Gatwick Airport Northern Runway Project

Appendix B: Response to York Aviation - Capacity and Operations

Application Document Ref: 10.24

PINS Reference Number: TR020005

Figure 11. Departure simulation results and August 2018 actual

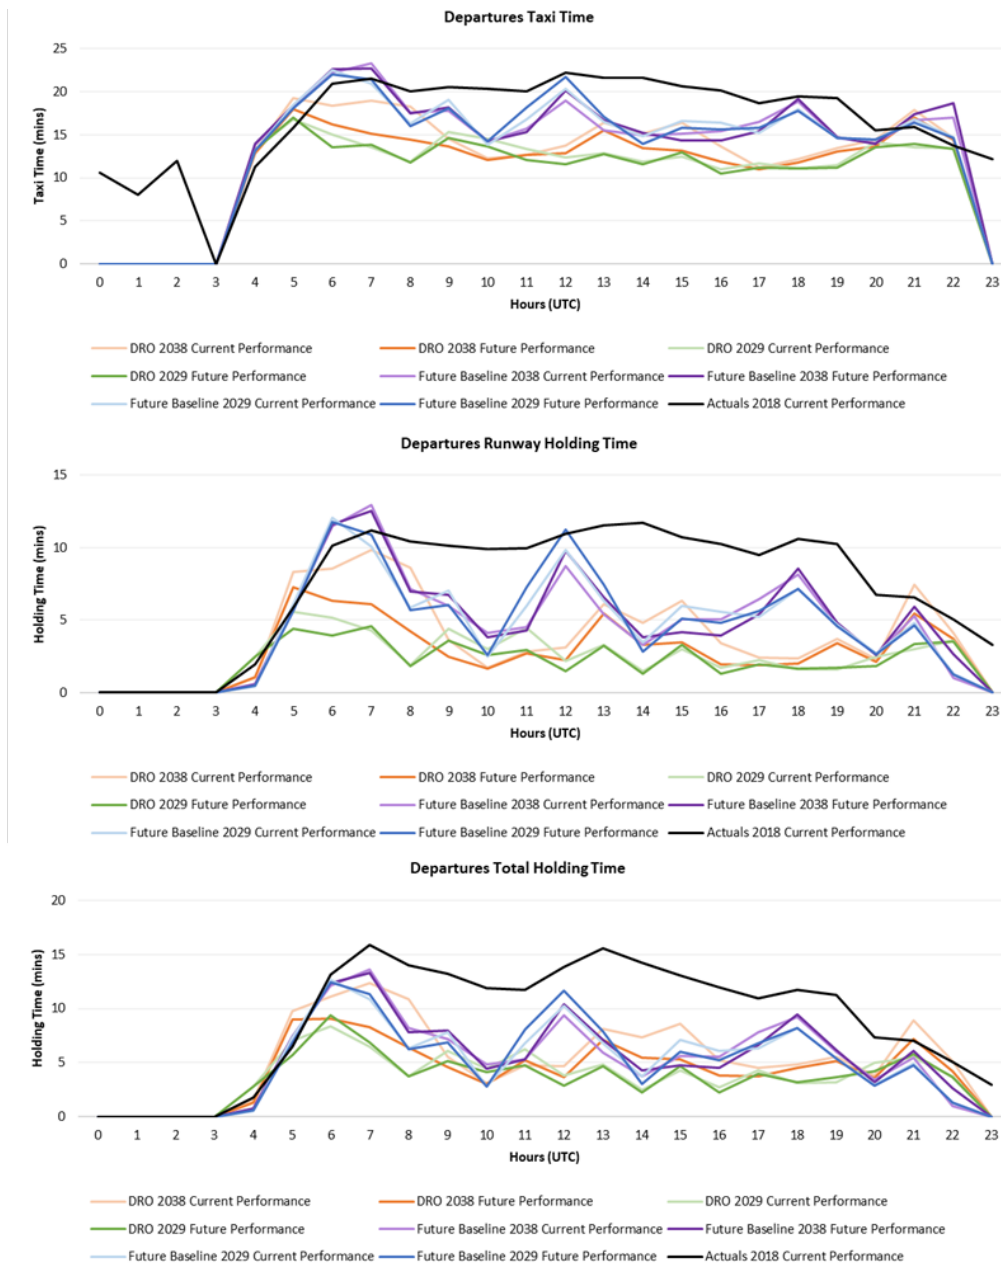
50.	<p>In terms of considering the level of capacity available, we have focussed on runway (Rwy) direction 26 as this is used for c.70% of the time. It is clear from Figure 11 of REP1-054, that although total departure delays may average 9.7 minutes across the day currently (2018) in the Rwy 26 direction [REP1-053, Table 2], they peak at an average of over 15 minutes in key peak periods of the day [REP1- 054, Figure 11]. Delays at this level exceed the normally acceptable level (to the airlines) of 10 minutes average delay in busy periods (typically 3-4 hours) and goes some way to explaining the concerns expressed by the airlines regarding the resilience of the current</p>	<p>GAL agrees with the rationale for the focus on the runway 26 direction as the prevailing direction of operation.</p> <p>First wave slots at London Gatwick are in high demand as their demand significantly outweighs capacity, hence even with full knowledge of the expected departure holding time, first wave slots remain oversubscribed.</p> <p>The 2018 peak total departure holding, referenced by York Aviation, is between 0700 & 0759 UTC which is a high demand hour for airlines. In Summer 2024 this hour is declared at 52 movements, in the live schedule (as of 03/05/2024). 0700 UTC on the busy day is fully utilised along with every other Friday between start of June and end of</p>

<p>operation, notwithstanding that we do understand that GAL has been clear of the delay implications in declaring capacity available at the current levels.</p>	<p>September, demonstrating the popularity of this hour despite higher holding time than other hours.</p> <p>The holding times airlines should expect throughout the day are fully detailed as part of the declaration process hence this is not considered ‘delay’ but rather ‘holding’ which should be accounted for in block times. Block times are the time between scheduled departure from stand at the origin airport and scheduled arrival on stand at the destination airport. As well as the flight time the block time should include taxi time and expected holding time for both departure and arrival.</p> <p>As per note 49 above, GAL still seeks to improve holding times and has initiated a number of performance improvement initiatives to support reduction in holding times and improved resilience. However, due to the inherent lack of capacity, these projects won’t deliver the same level of improvements that will be possible through NRP.</p> <p>In the baseline case, the addition of the new RET (which is fully in place) reduces peak total departure holding time to 13.6 minutes at 0700 UTC, and 12.1 minutes at 0600. All other hours remain below 10 minutes. Given that in the baseline the peak total departure holding reduces compared to 2018, the levels of holding are not expected to hinder London Gatwick’s ability to fill the baseline schedule.</p> <p>In addition, London Gatwick’s low cost to operate for airlines, compared to other nearby airports, and high passenger demand, especially in a constrained scenario where</p>

<p>increased capacity is not delivered through the proposed development, means that the baseline capacity is expected to be filled.</p>
<p>51.</p>	<p>We understand that these delays are being mitigated to some degree now that the new rapid exit taxiway is in operation enabling many arriving aircraft to clear the runway more quickly. However, we understand from the documents that it is not GAL’s intention to make further increases to peak hour declared capacity and to allow airlines to realise the benefits in terms of reduced delay. At paragraph 3.3.2 of REP1-053, GAL suggests that there are further enhancements that could be in prospect to improve the resilience of the operation. However, as we note below, these enhancements have been assumed not just to add resilience in the case of dual runway operations with the NRP but to be factors enabling higher capacity to be delivered and usable by the airlines. We have doubts that this is robust at this stage as GAL, itself, acknowledges that the real impact of these on the operation and how much capacity gain they might deliver is not yet known.</p>	<p>GAL has assumed the availability of the new rapid exit taxiway (RET) in all scenarios due to it already being in operation and delivering benefits to the operation. The initial performance of the new RET is in line with the benefits assumed in the modelling for the baseline case, improving reliability of performance and giving the equivalent benefit of +1 ATM/H. GAL has also accounted for well-developed future initiatives such as reduced departure separation (RDS) and optimised sequencing that will primarily improve resilience against sub-optimal fleet mix and SID allocation. GAL has refrained from making assumptions regarding any future initiatives in their infancy, such as time-based separation.</p> <p>RDS technical implementation is completed and the process of embedding the new process into the operation will take place over the remainder of 2024, resulting in improvements materialising in 2025. Optimised sequencing is planned for delivery in 2025.</p> <p>Given the mature stages of implementation of RDS and optimised sequencing the future scenarios should factor in the impact of these projects.</p> <p>However, for transparency, the Capacity and Operations Summary Paper Appendix: Airfield Capacity Study [REP1-054] section 5, 6 & 7 present the simulation results based both on current performance and with the phased introduction of reduced departure separation and optimised sequencing (for</p>

<p>NRP only), so the impact of the future initiatives can be clearly seen.</p> <p>As per the results, RDS provides limited benefit in the baseline case as the single runway capacity limits departure rates.</p> <p>RDS provides improved average departure taxi time by 1.4 minutes across the day. Optimised sequencing has limited impact on average holding, however it supports by reducing the outlier holding times by 40%.</p>
